DEPARTMENT OF PARKS AND COMMUNITY SERVICES

February 12, 2024

Subject: Mayberry Filing No.2A CS Rezone - (CS234)

REZONING EXHIBIT

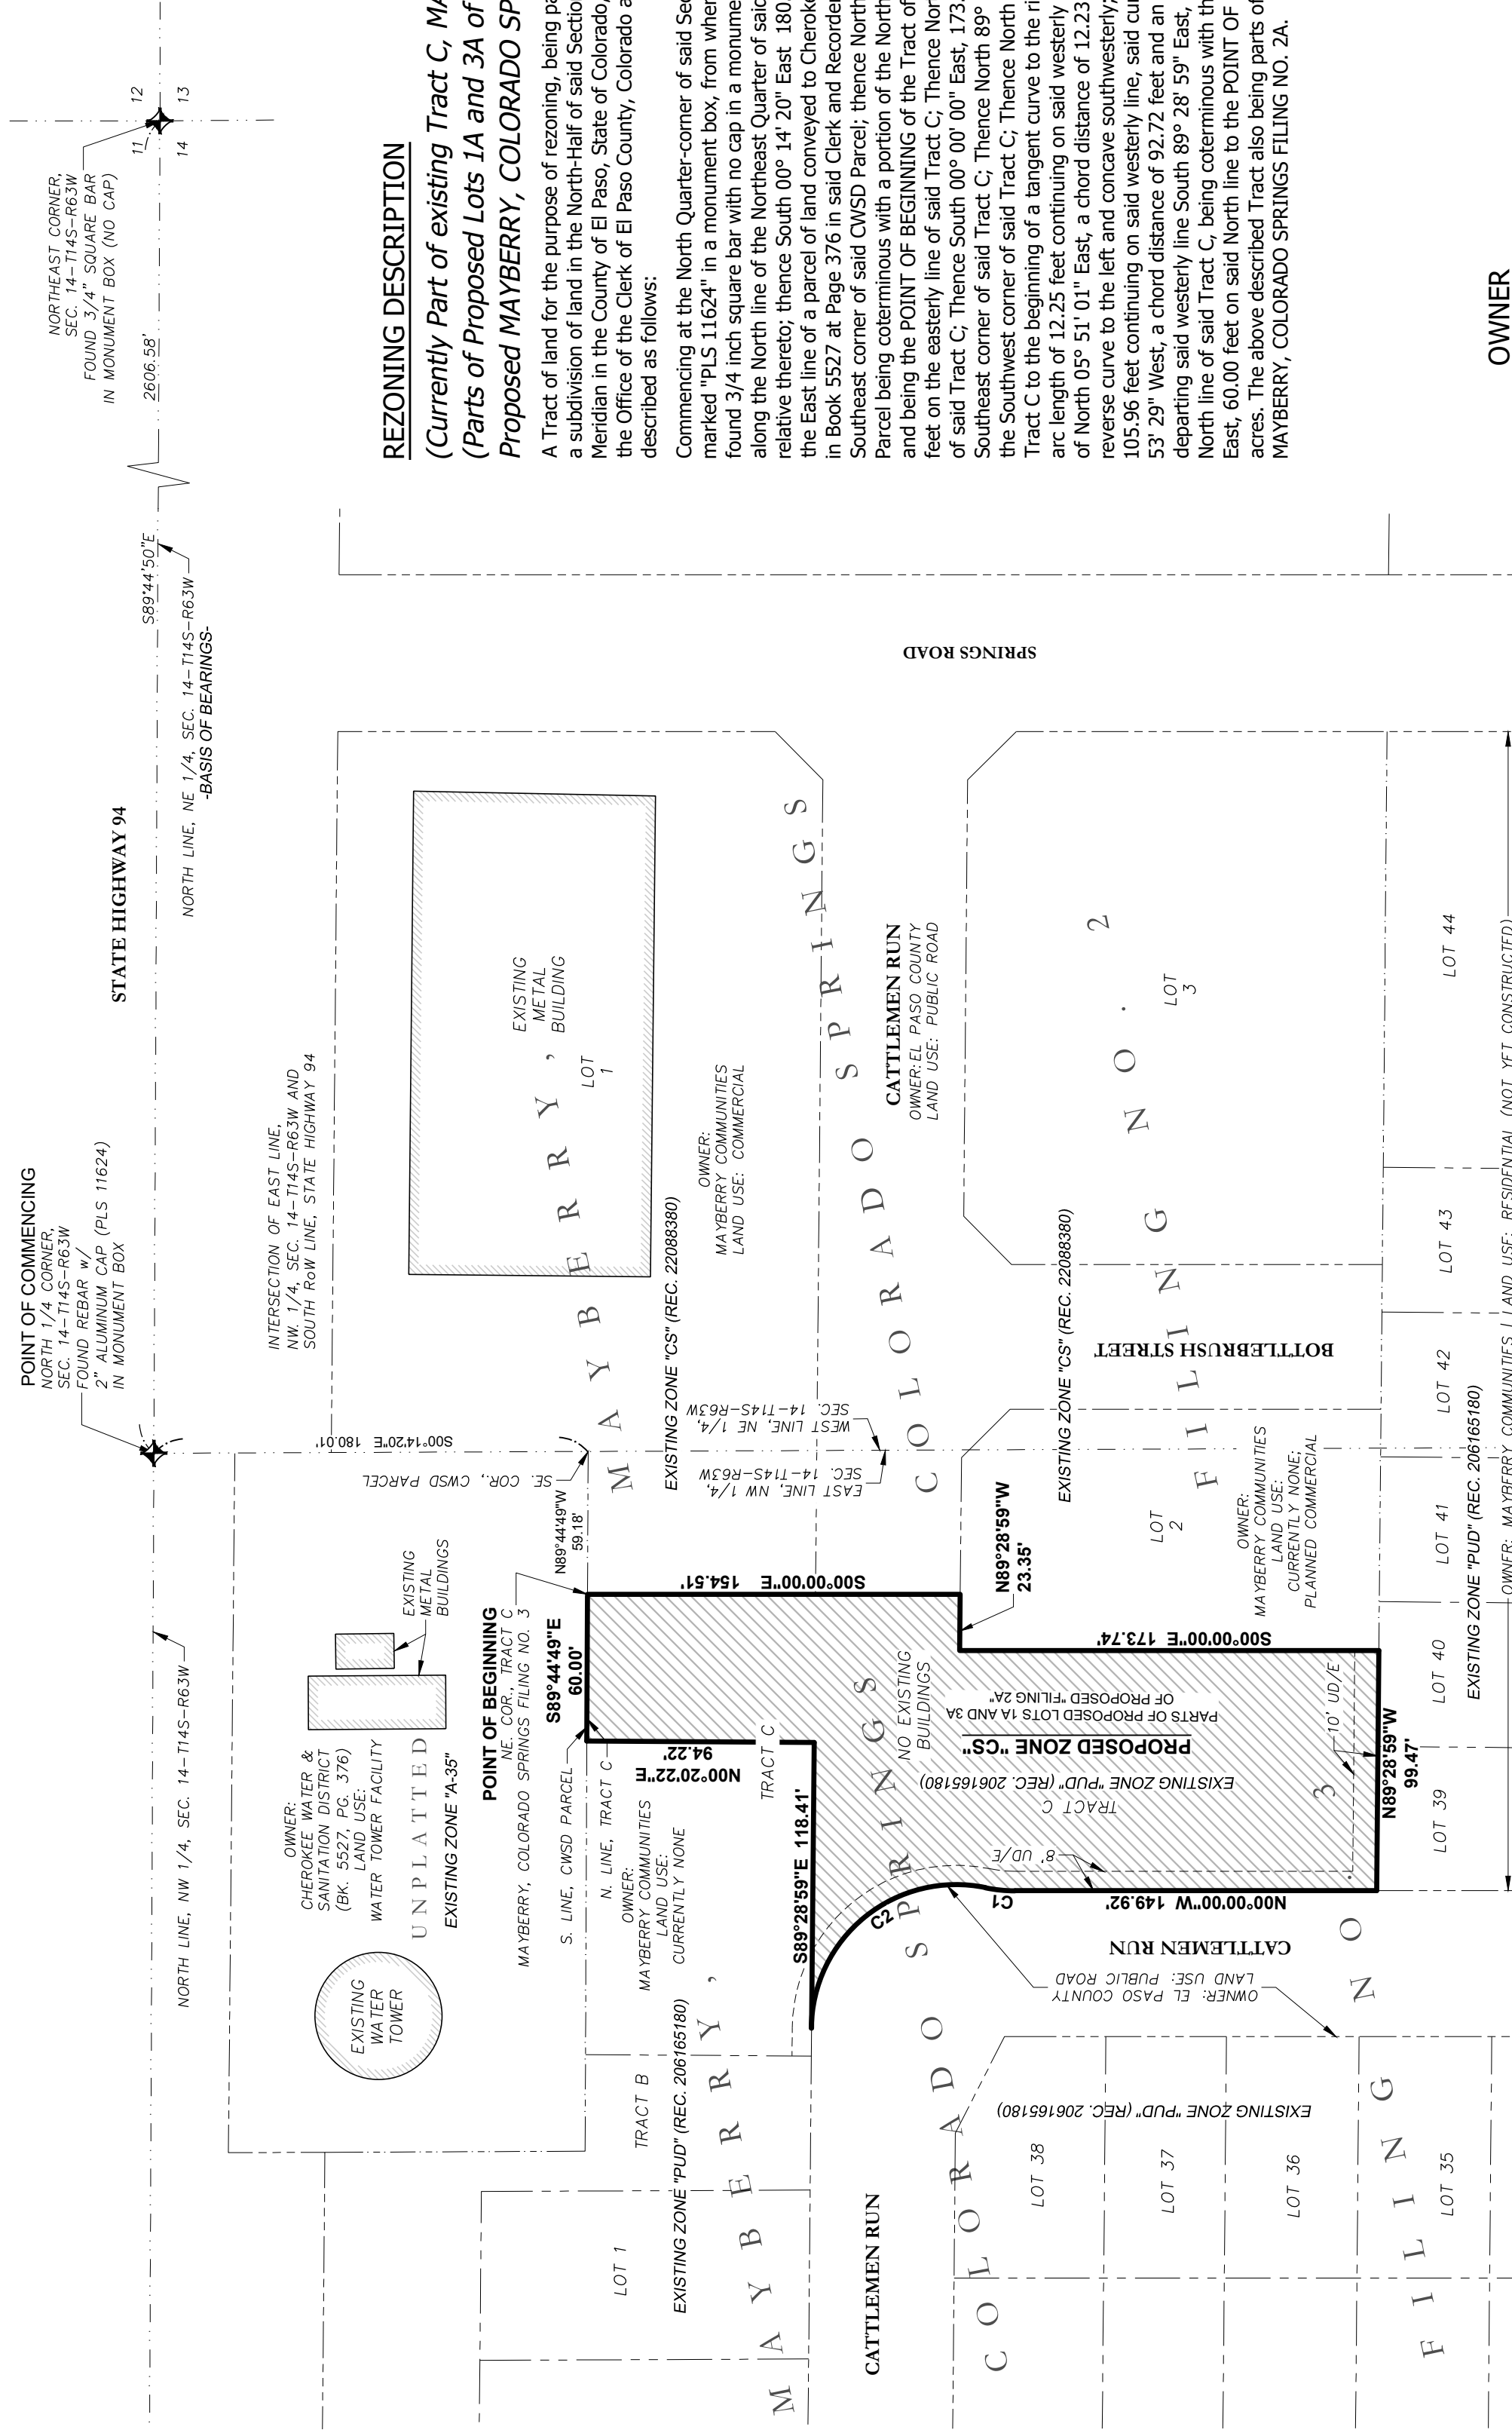
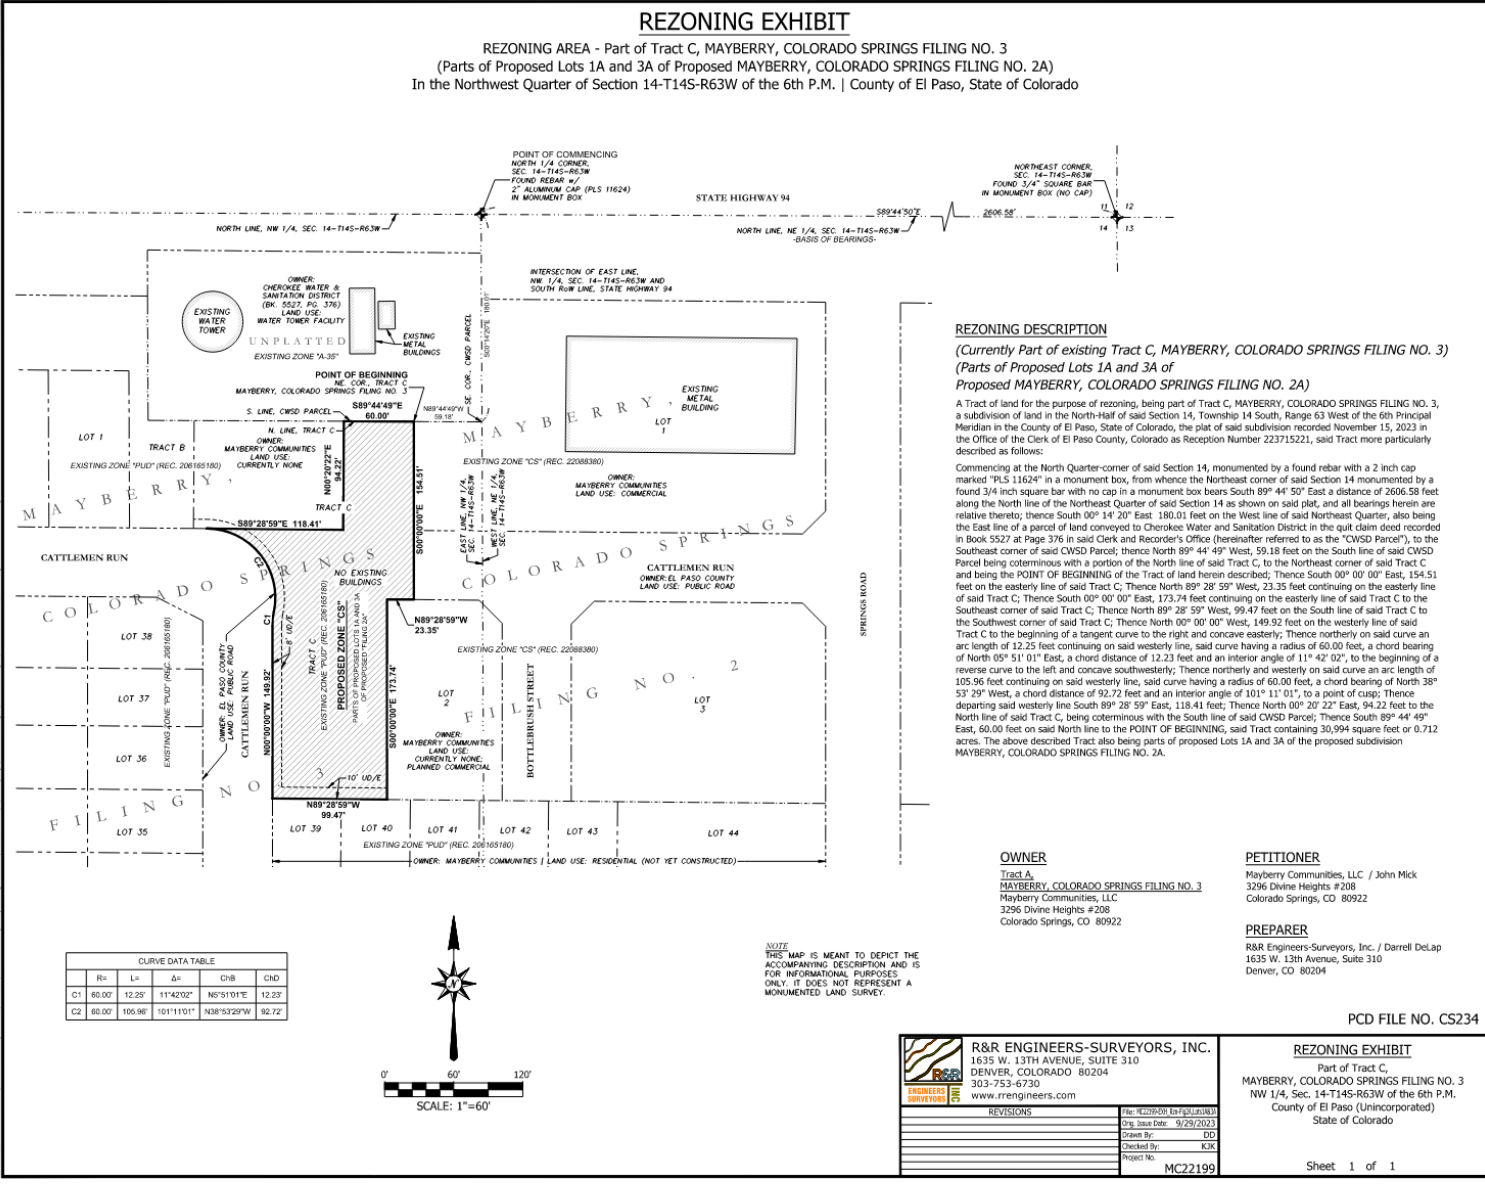
County Parks requests trail easements where development projects impact proposed County trails. As it pertains to this application, the County requests that the landowner provide a 25-foot public trail easement along the south side of Highway 94 and around the south side of the Cherokee Water & Sanitation parcel to make a connection to allow for the construction and maintenance by El Paso County of the Highway 94 Primary Regional Trail, and this easement shall be shown and dedicated to El Paso County on the Final Plat.

Recommend that the Planning Commission and the Board of County Commissioners include the following conditions when considering and/or approving the Mayberry Filing No.2A CS Rezonet: (1) Provide a 25-foot public trail easement along the south side of Highway 94 outside of the public right-of-way and south of the Cherokee Water & Sanitation parcel that allows for the construction and maintenance by El Paso County of a Primary Regional Trail, and this easement shall be shown and dedicated to El Paso County on the Final Plat. (2) Provide an alternative trail alignment for the Highway 94 Primary Regional Trail through the Mayberry development for El Paso County Parks review.
